**KIRKLEES METROPOLITAN COUNCIL
INVESTMENT & REGENERATION SERVICE**

DELEGATED DECISION TO DETERMINE PLANNING APPLICATIONS

Reference No:	2023/62/91612/W
Site Address:	154, Lockwood Road, Lockwood, Huddersfield, HD1 3QX
Description:	Change of use and alterations to convert dwelling to 5 bed HMO and erection of front dormer extension
Recommending Officer:	Tom Hunt

DECISION - REFUSED

Attic - P
1 : 50

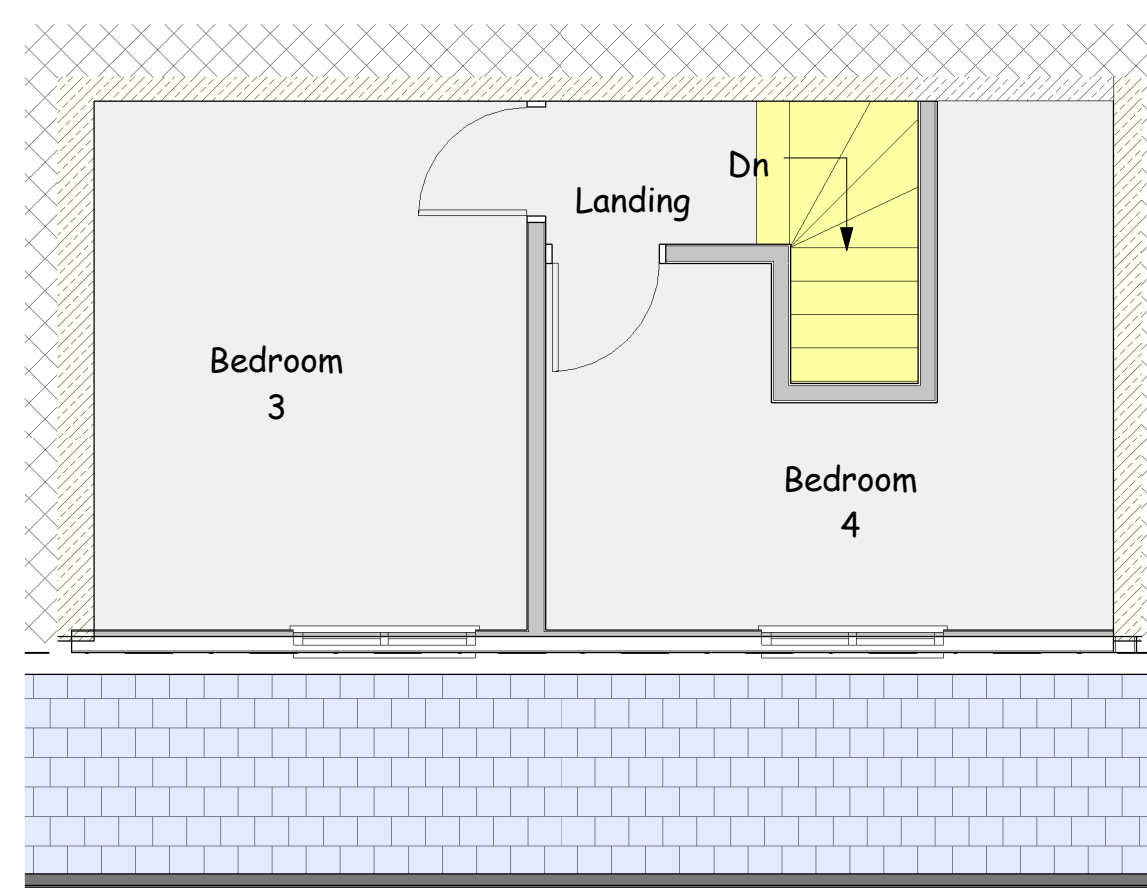
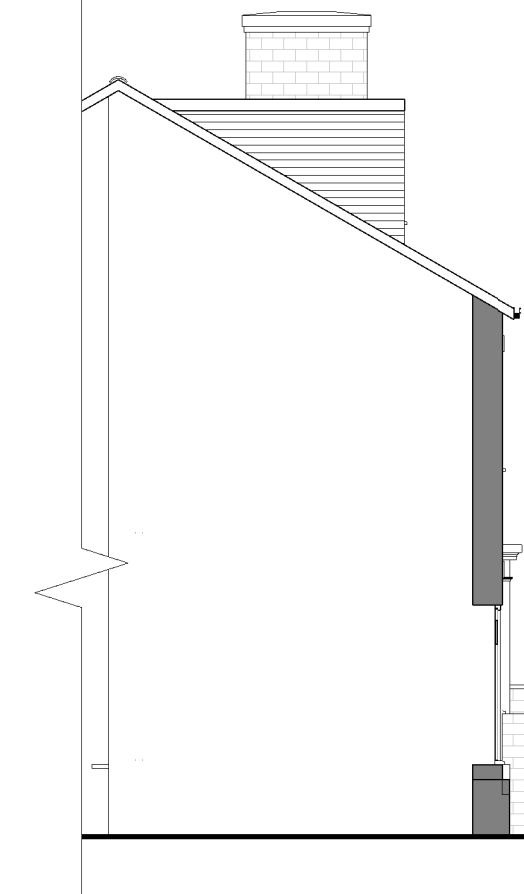
This would be 7m width, 1.95m height and project 3.3m from the roof plane. This would appear set down from the ridge by 0.3m, set back from the eaves by 1.6m and would not be set in from the flank boundaries.

The front dormer would remove a chimney and would take up the majority of the front roof elevation with a minimal set down from the roof ridge and no set back from the flank roof boundaries to form a prominent and domineering extension to the host. While it would be set back from the eaves of the property, this would not be sufficient to form a subservient extension to the host and would not comply with LP24a or c. The materials proposed would be low quality uPVC horizontal cladding, this could be conditioned to have materials to closely match the slate tile roof colour if this was required in order to facilitate the proposal in terms of visual amenity. Considering the fenestration, one window would not be aligned with the existing front elevation fenestration of the host and would appear inharmonious to the host accordingly.

Considering the wider locality, the roofscape is typically uninterrupted by dormers excepting two aforementioned dormers. No. 154 would be separated from both by intervening properties with no desirable grouping to mitigate against its protrusion in the roofscape adding to the impression of undesirable visual clutter in a prominent and high traffic location. In addition, the dormer design would not be aligned with both examples given forming an unsympathetic addition to the roofline of the terraced residential properties.

The proposed front dormer extension, by virtue of its scale, massing, design and relationship with the host dwelling in a prominent location, would result in a disproportionate and incongruous addition to the original dwelling and would have a design that form an inharmonious addition within the roofscape of its locality. The development is contrary to Policy LP2 and LP24a and c) of the Kirklees Local Plan and Policy contained within Chapter 12 of the National Planning Policy Framework.

Bedrooms, in the main, meet NDSS excepting for two identified as Bedroom 3 which has an under supply of 0.8sq.m by area and is less than the minimum expected width for good living conditions; and Bedroom 4 in the dormer with a substantially substandard 1.5m width when compared to the expected minimum of 2.15m width. While not all the bedrooms meet NDSS, this could be acceptable subject to further reflection of relevant matters.

2. The proposed front dormer window, by reason of its siting, massing, form and design, would introduce an unsympathetic, incongruous, disproportionate and dominant addition to the host property No. 154 Lockwood Road. The proposed dormer would not appear in keeping with the largely unaltered roofscape of terraced properties in the area. The development would therefore cause detrimental harm to the visual amenities and overall character of the area. This is contrary to Policies LP1, LP2 and LP24(a and c) of the Kirklees Local Plan, and Chapter 12 of the National Planning Policy Framework.

First Floor - P
1 : 50

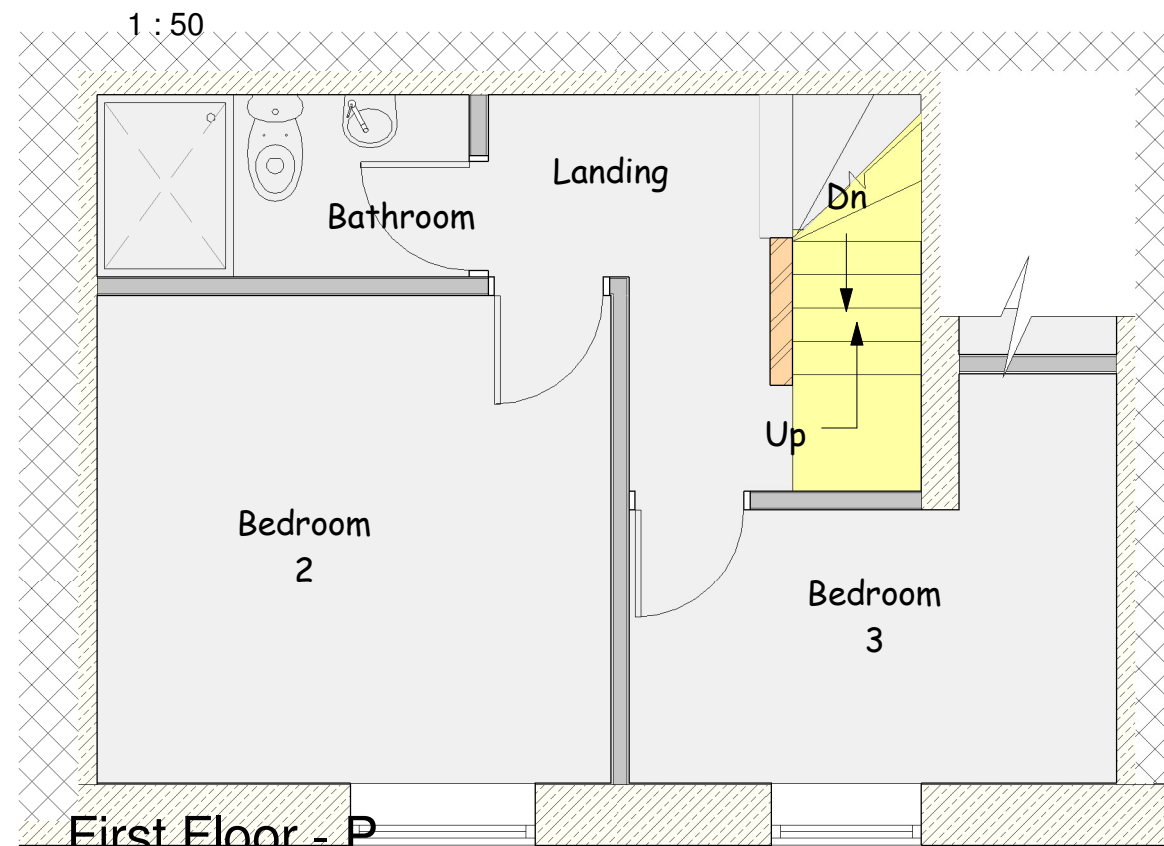
- Cellar – kitchen/dining and storeroom (25sq.m.). Daylit through an enlarged lightwell
- Ground Floor – Bedroom 1 (11.6sq.m – double bedroom), Hall and Bathroom
- First Floor – Bedroom 2 (11sq.m.), Bedroom 3 (6.7sq.m. and minimum 1.8m width), Landing and Bathroom

Cellar - P
1 : 50

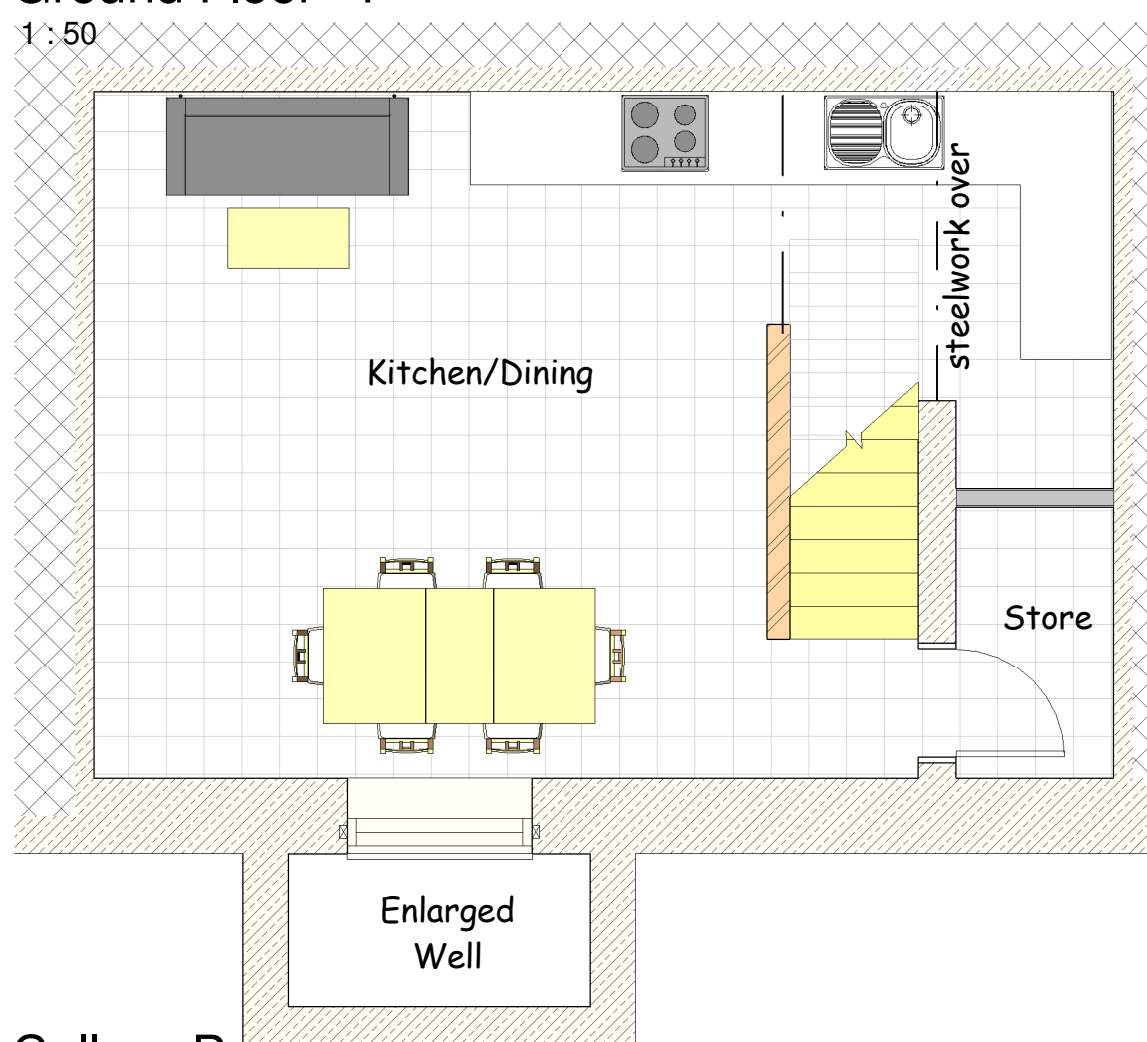
It would have an existing lightwell made larger to be 1m projection from the cellar window and 2m width and 1.3m depth. The original lightwell size was 0.3m projection x 1.3m width and 1.3m depth.

The only shared habitable room would be the kitchen/dining room in the cellar and this would have a third of its window area above highway ground level. Officers have significant concerns over the impact of the development on achieving high standards of amenity for future occupiers, in particular outlook, natural light and overbearing. The lightwell would be enlarged to provide more potential day lighting however the boundary wall and its iron railings would have some visual impact on outlook and overbearing adding to a sense of oppressive, visual enclosure for the occupiers. No sections were provided to demonstrate the expected field of outlook and natural light however given the extremely limited front 'amenity' area and closeness to the highway to the window and depth of the lightwell, this would not overcome Officers concerns in this regard.

The orientation of the cellar window is to the southeast and it is within a back-to-back property. Officers are concerned that this would offer a poor standard of daylighting to the habitable room with most of its day lighting at inadequate levels in the afternoon/evening to offer a good standard of amenity.

Whilst the property is constrained by its limited floorspace and what it can offer, Officers cannot support a dwellinghouse with such an intensified bedroom usage with such a poor standard of residential amenity regarding outlook and daylighting to the shared habitable room within the cellar. The proposal would fail to offer adequate storage space or any outdoor amenity space to relieve the poor standard of amenity.

1. The proposed development, by reason of the limited amount of useable storage space to the whole property and its limited internal floorspace provided within Bedroom 3 and 4, would provide a poor standard of amenity to future occupiers. The proposed use of the basement window for a kitchen/dining room mostly below ground level would provide a poor level of outlook and be of an oppressive nature with low daylighting for the shared amenity of future occupiers. Therefore, the development would be contrary to the aims of paragraph 130(f) of the National Planning Policy Framework, the Policy LP24(b) of the Kirklees Local Plan.
